**Consultation Response from KC,  
Lead Local Flood Authority**

**2024/92444 Land North of, Denby Lane, Grange Moor, Huddersfield, WF4 4BH**

**Erection of 21 dwellings and associated works with means of access from Denby Lane**

**Date Responded: 01/11/2024.**

Results for 100 year +40% CC Critical Storm Duration. Lowest mass balance: 99.90%

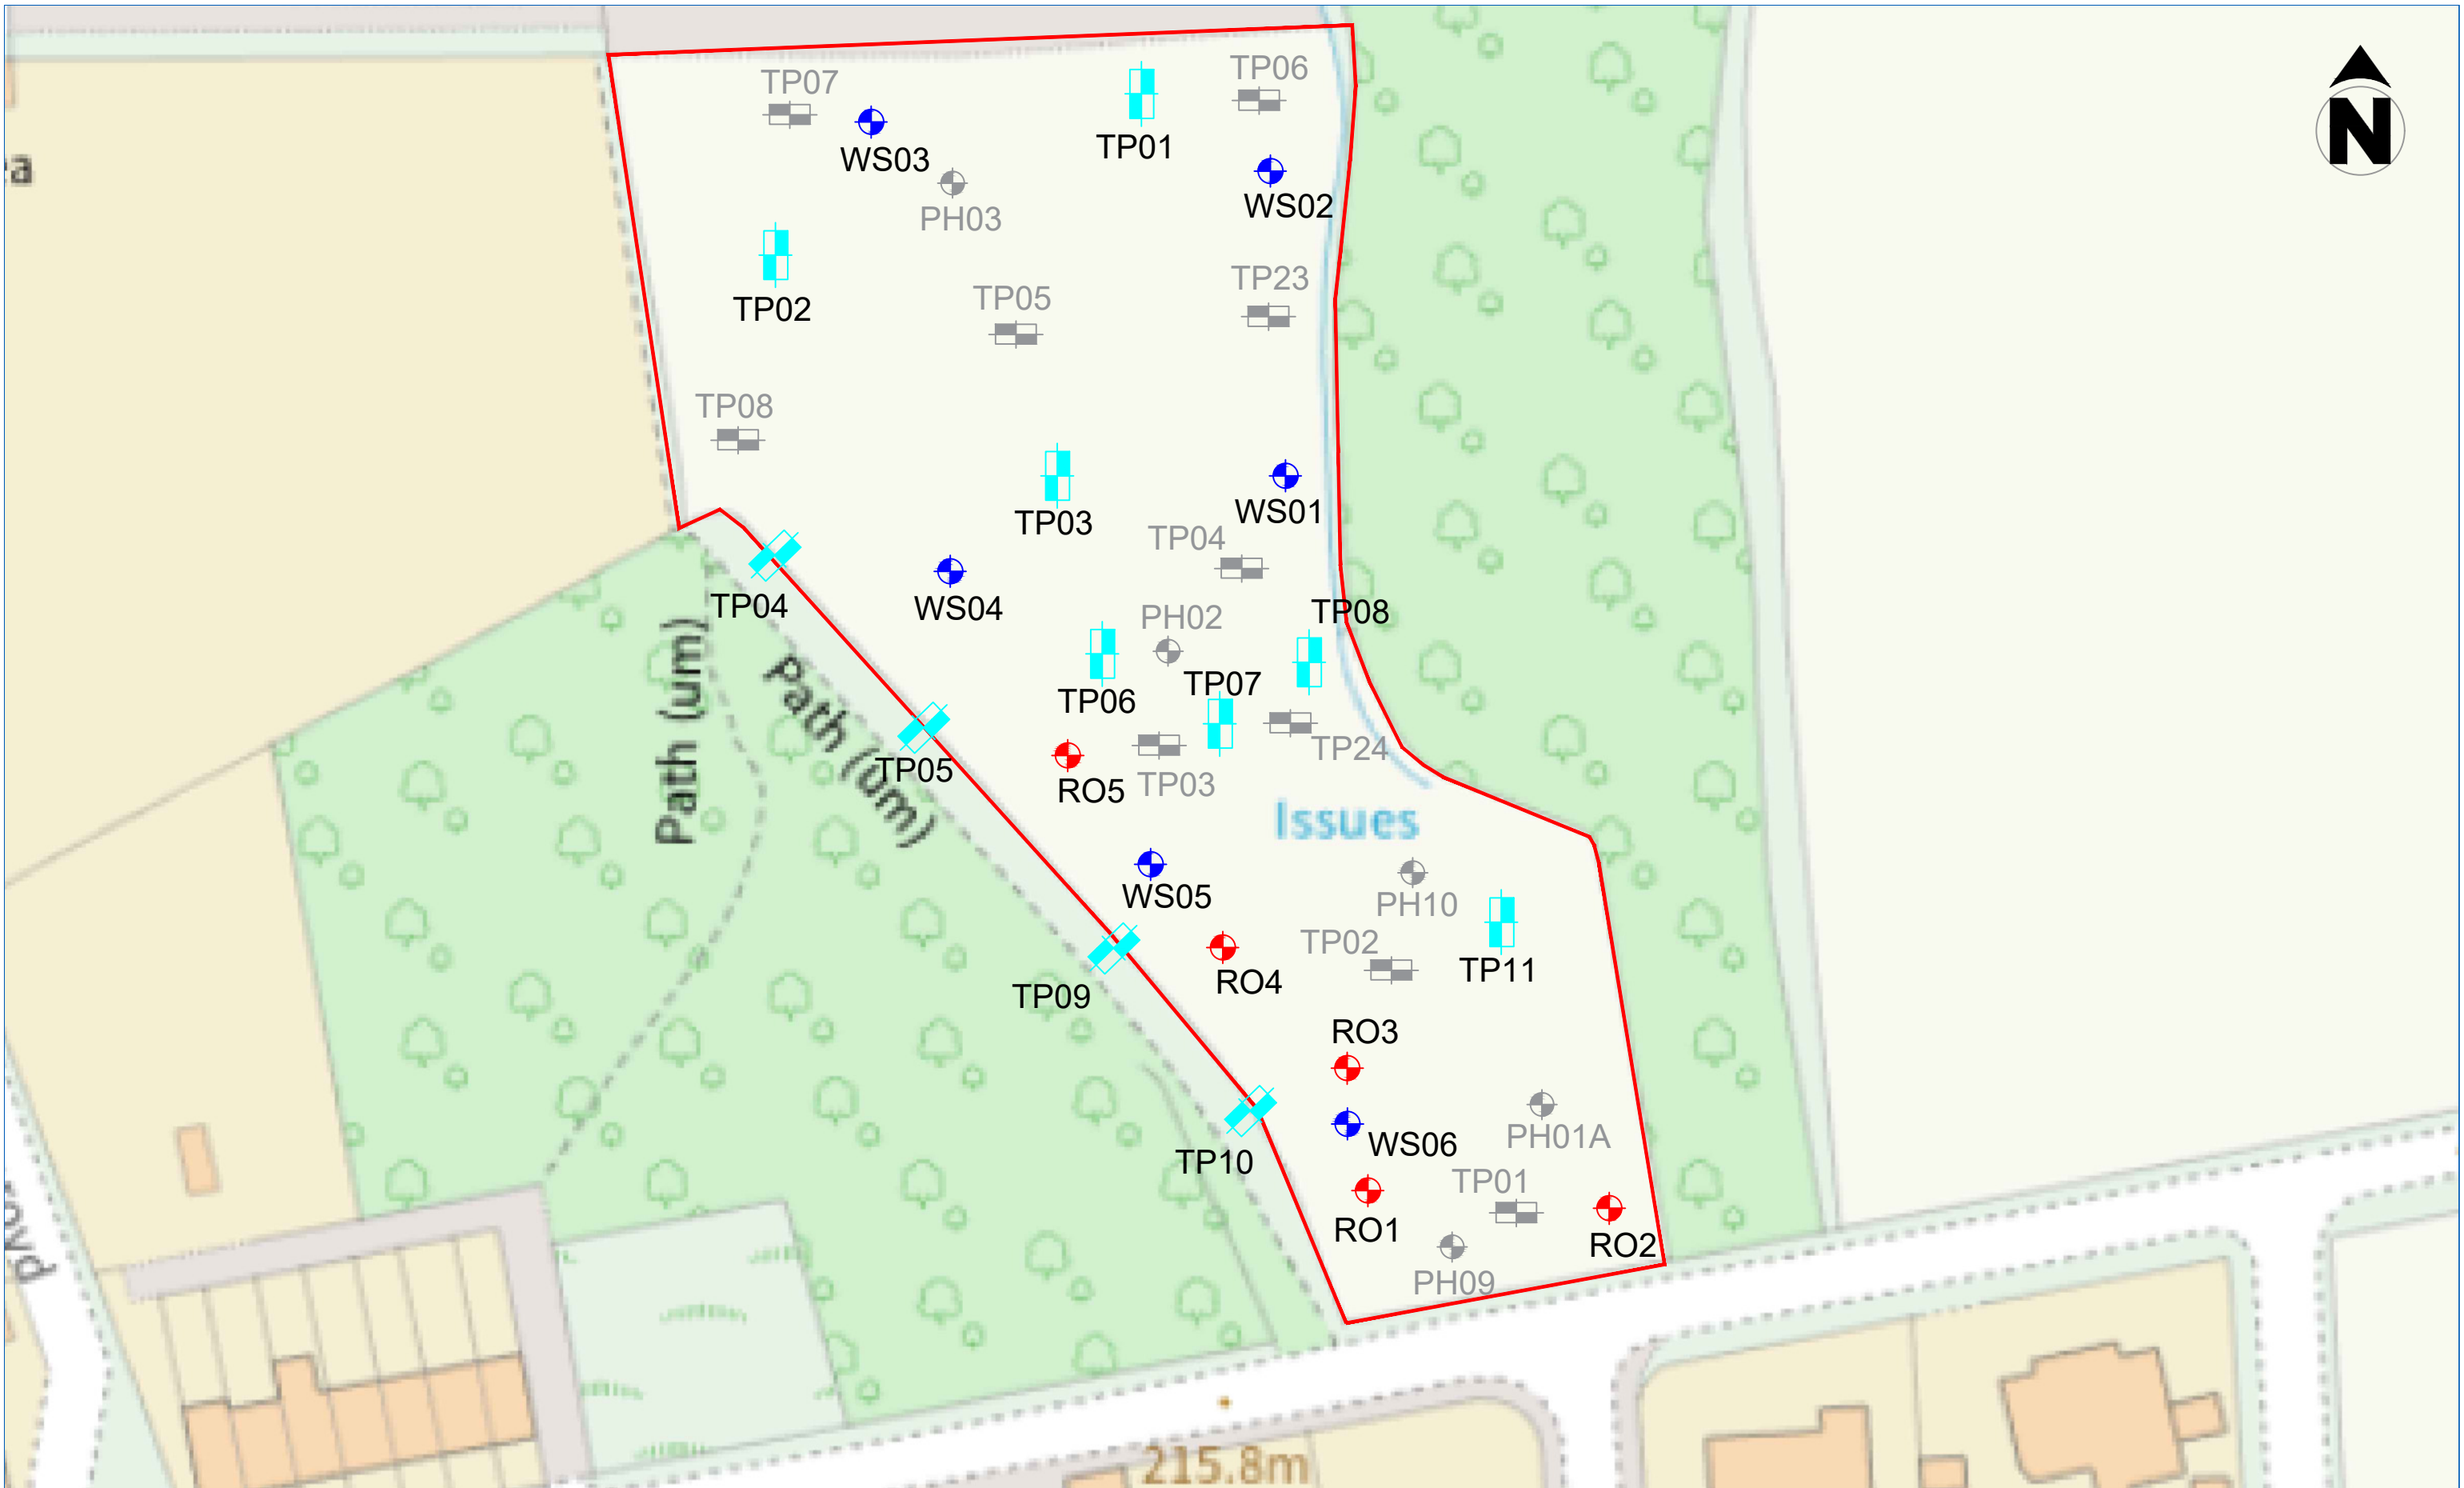
The FRA states that the allowable surface water discharge rate will be 3.5l/s – this will be acceptable to the LLFA provided the outlet diameter of the flow control device is not less than 75mm. It is noted that the hydraulic calculations in Appendix D of the FRA assume a discharge rate of 5.0l/s – these calculations will need to be revised with the rate set at the minimum for a 75mm diameter flow control device.

DRAWN	MJM	CHK'D	MJM
SCALE	1:250 @ A1	DATE	20.03.24
JOB No	24017	DRG No	101
REV	I

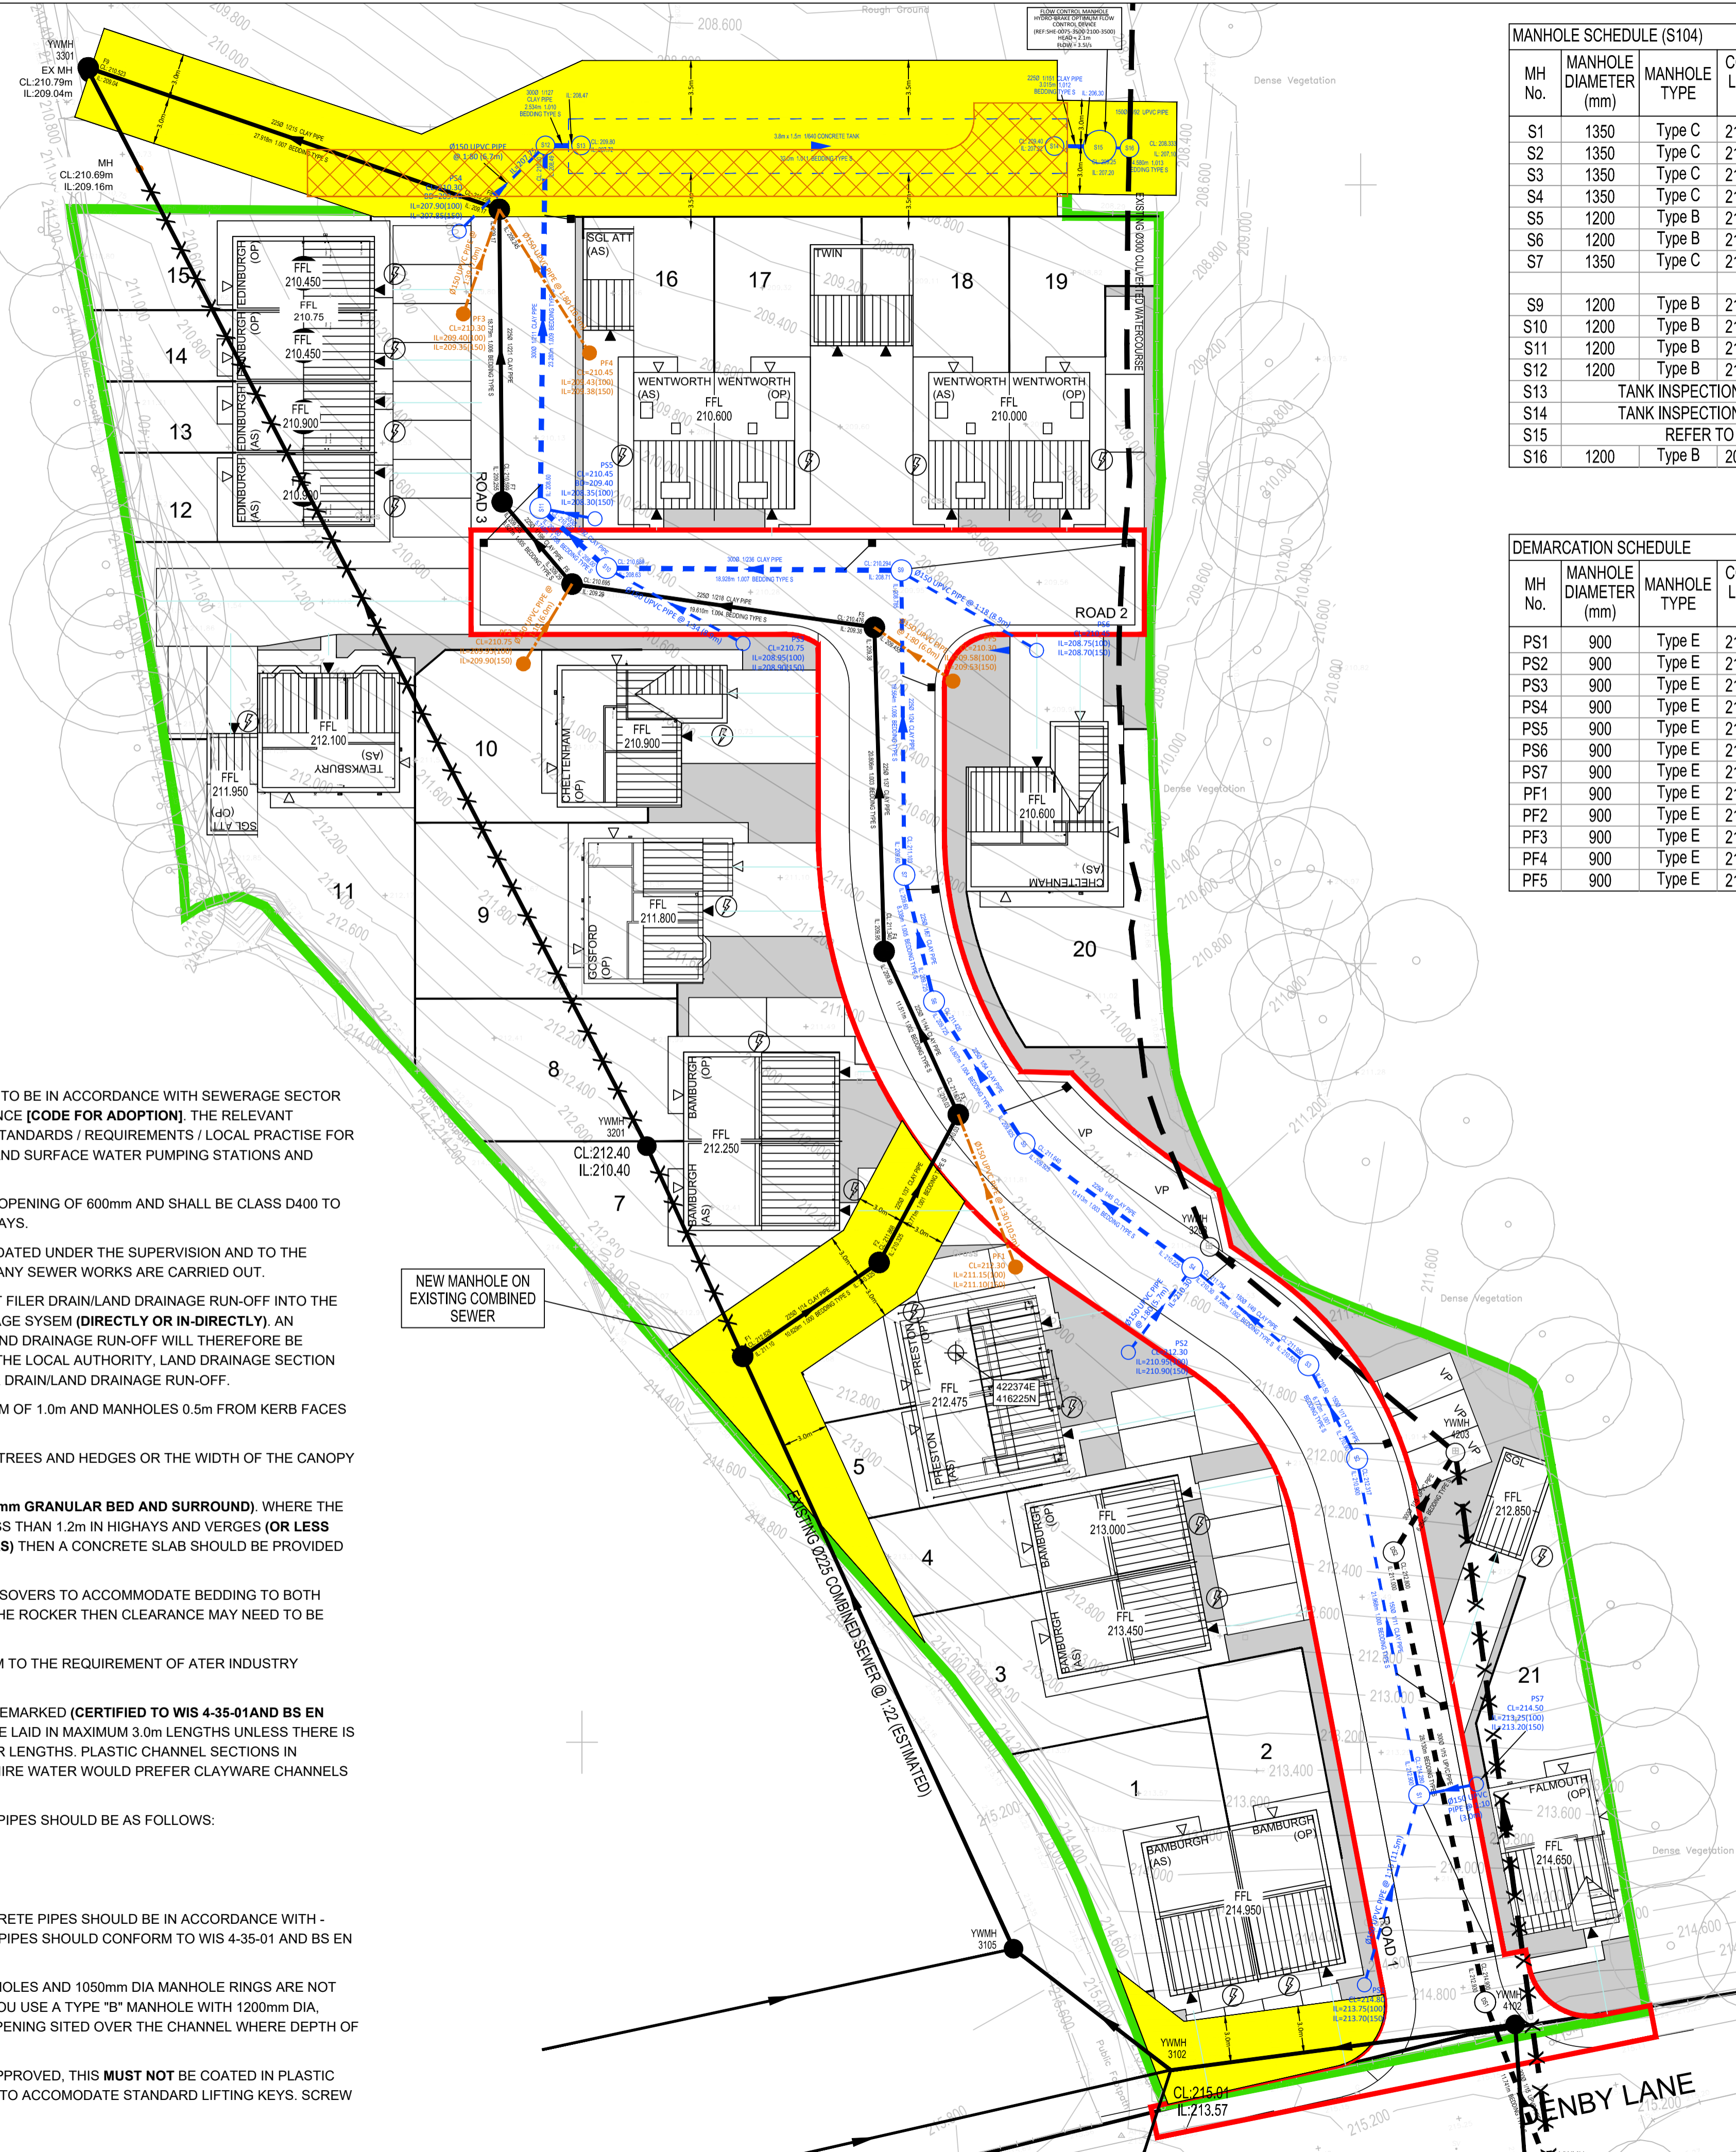
NOTE: Drawing 24017-101 indicates that the attenuation tank is located **outside** the red line boundary and the Planning Officer's attenuation is drawn to this. The comments below are made on the assumption the red line boundary will be extended to include the land proposed to be occupied by the tank.

It is noted that the development will require third party permissions to discharge the surface water drainage off site to the culverted watercourse on the eastern side of the site (Briestfield Beck). Agreement with the neighbouring landowner will therefore be required to allow for the surface water outfall.
